HILLPOINTE APARTMENTS AT PETERSON SITE DEVELOPMENT PLAN

Please note that the Final Plat and Rezoning must be approved prior to final review and approval of this Site Development Plan.

PPR-26-13
PCD FILE NO.

# HILLPOINTE APARTMENTS AT PETERSON SITE DEVELOPMENT PLAN

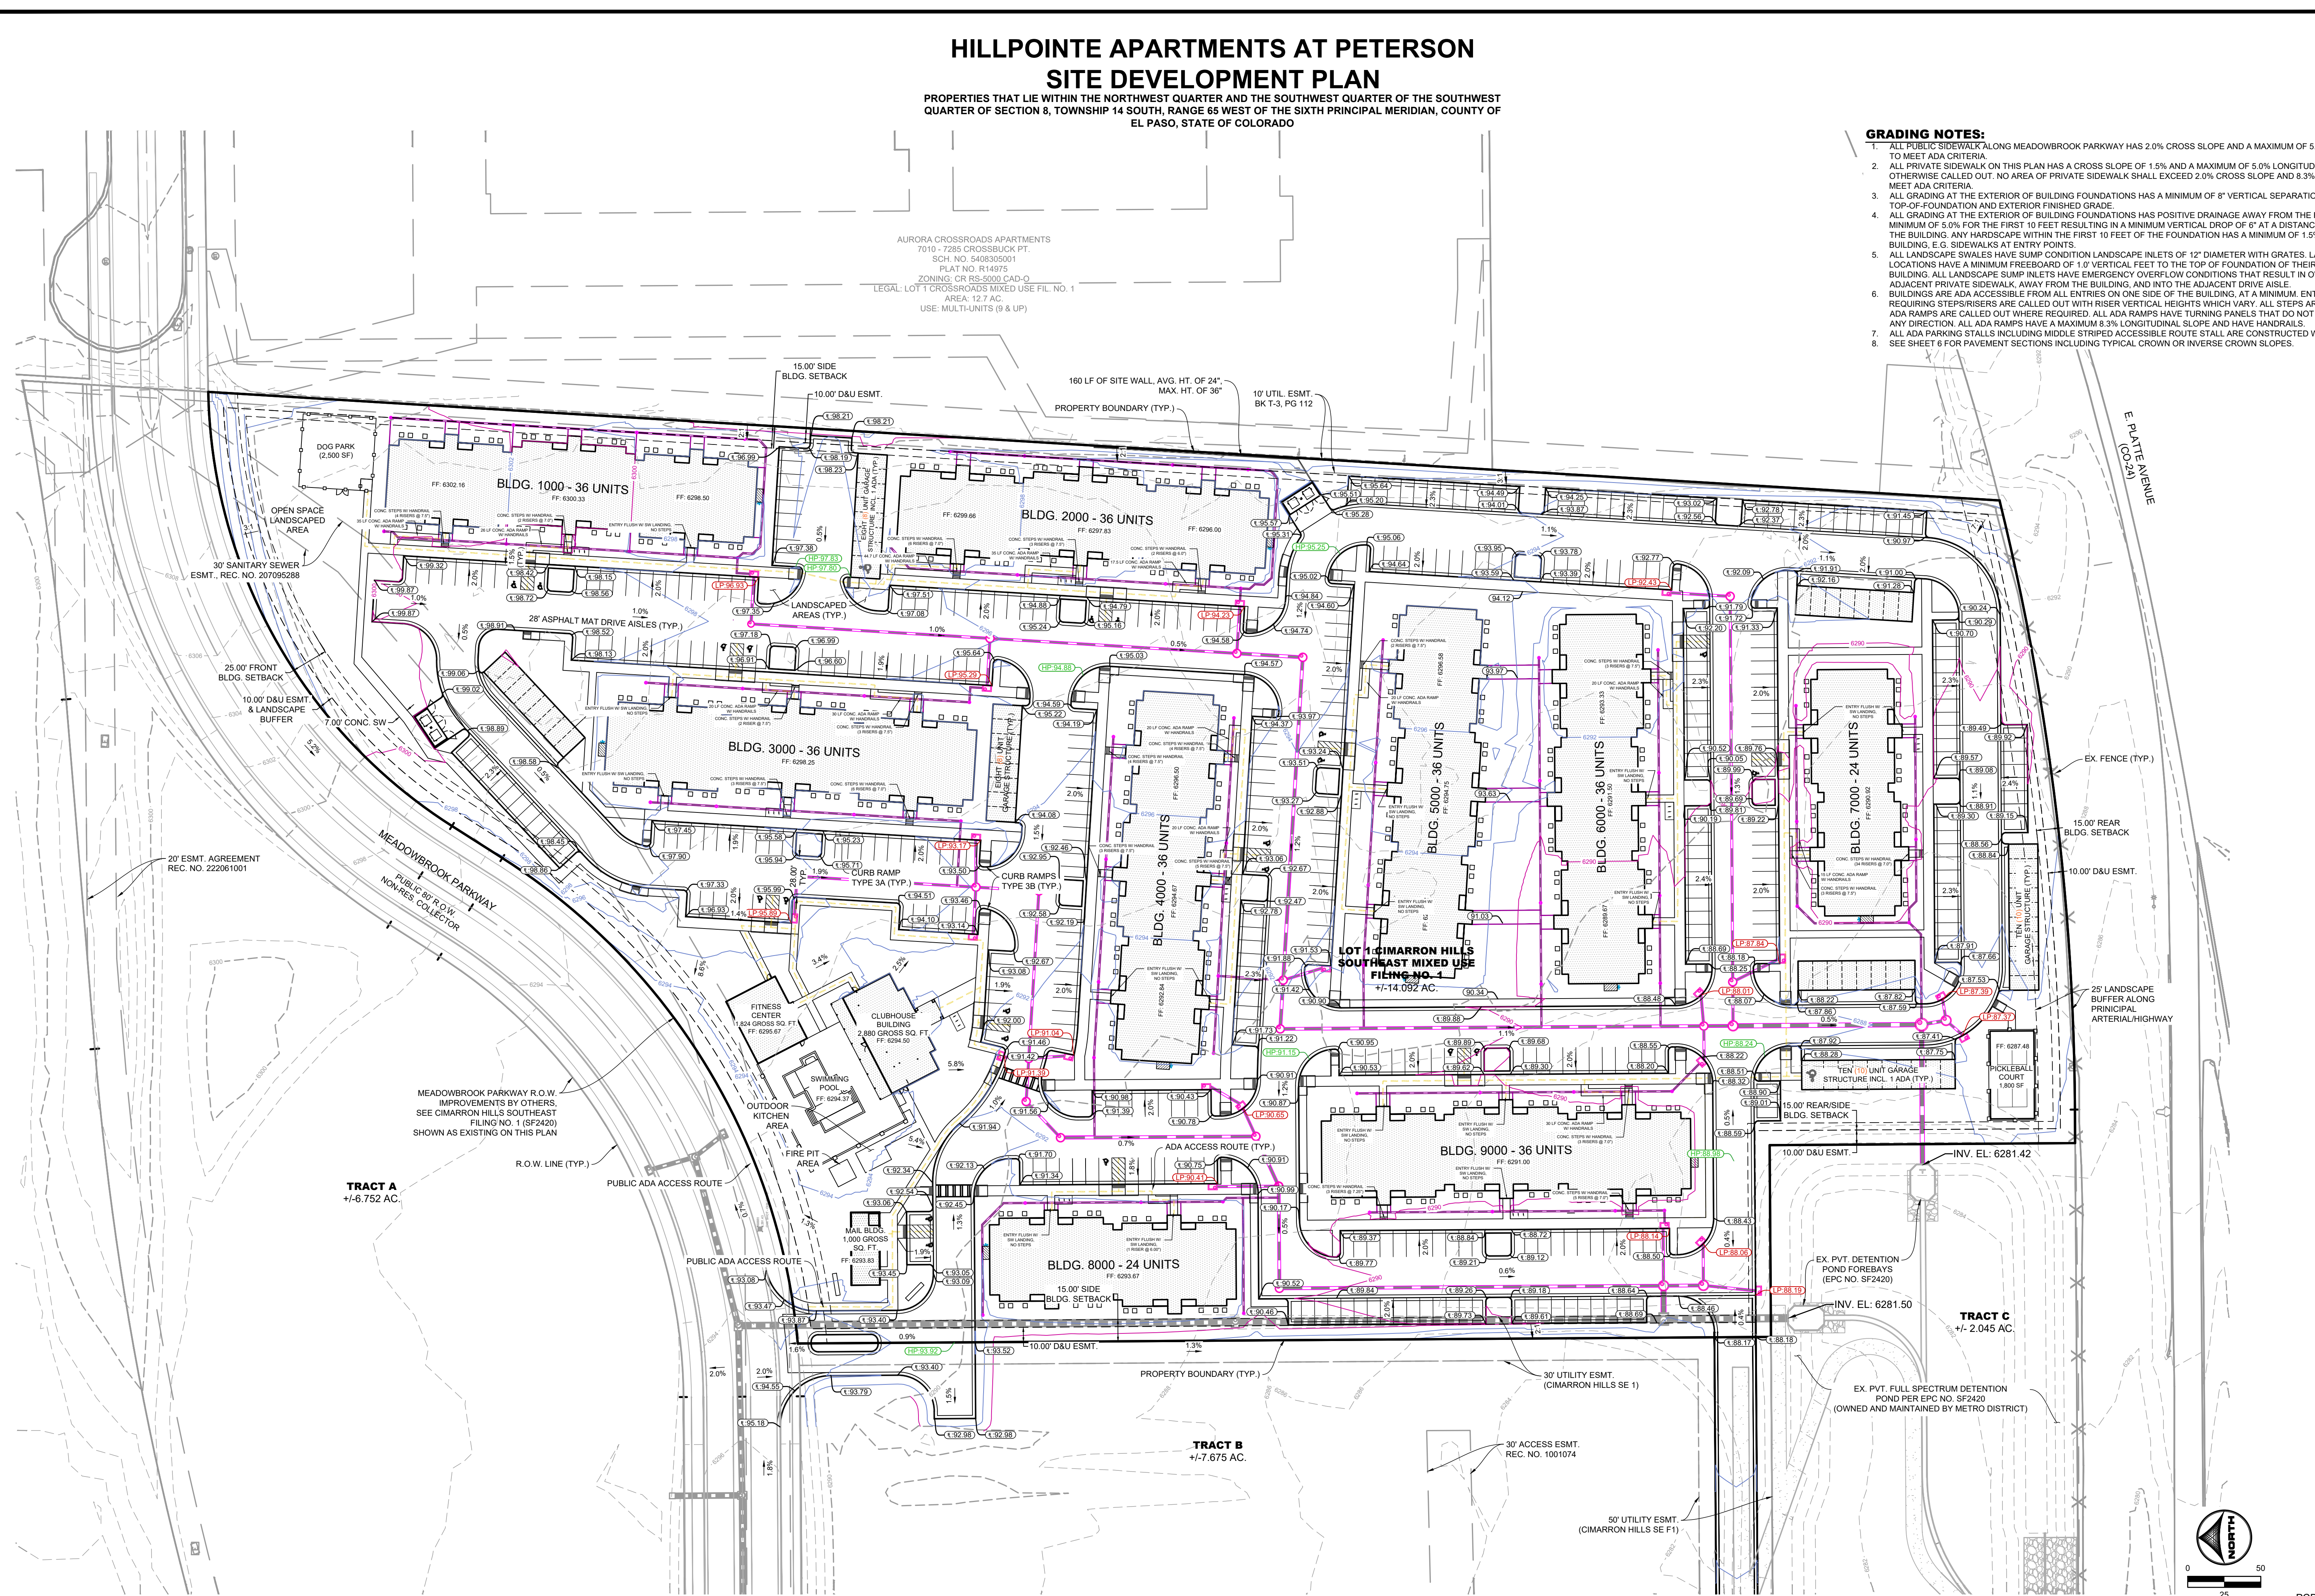
Per the TIS, "an eastbound right turn deceleration lane and westbound left turn deceleration lane at Site Access along Meadowbrook Parkway may also be required." Please add these turn lanes to the plan and reference Construction Drawing set where design is located.

Per ECM Section 2.3.8 Roadways shall have a turnaround. Please provide a turnaround.

This is not the current name for this parcel

HRG Response:
Turn lanes and striping now shown and labeled as under separate CDR file.

HR Green Response:
This private roadway is looped internally and has sufficient fire access as demonstrated by the Fire Protection Plan. The dead ends do not exceed 150' and are only added for parking access. ECM 2.3.8 should not apply.

HRG Response:
Kept as this description as this will be what it is at approval of the SDP.
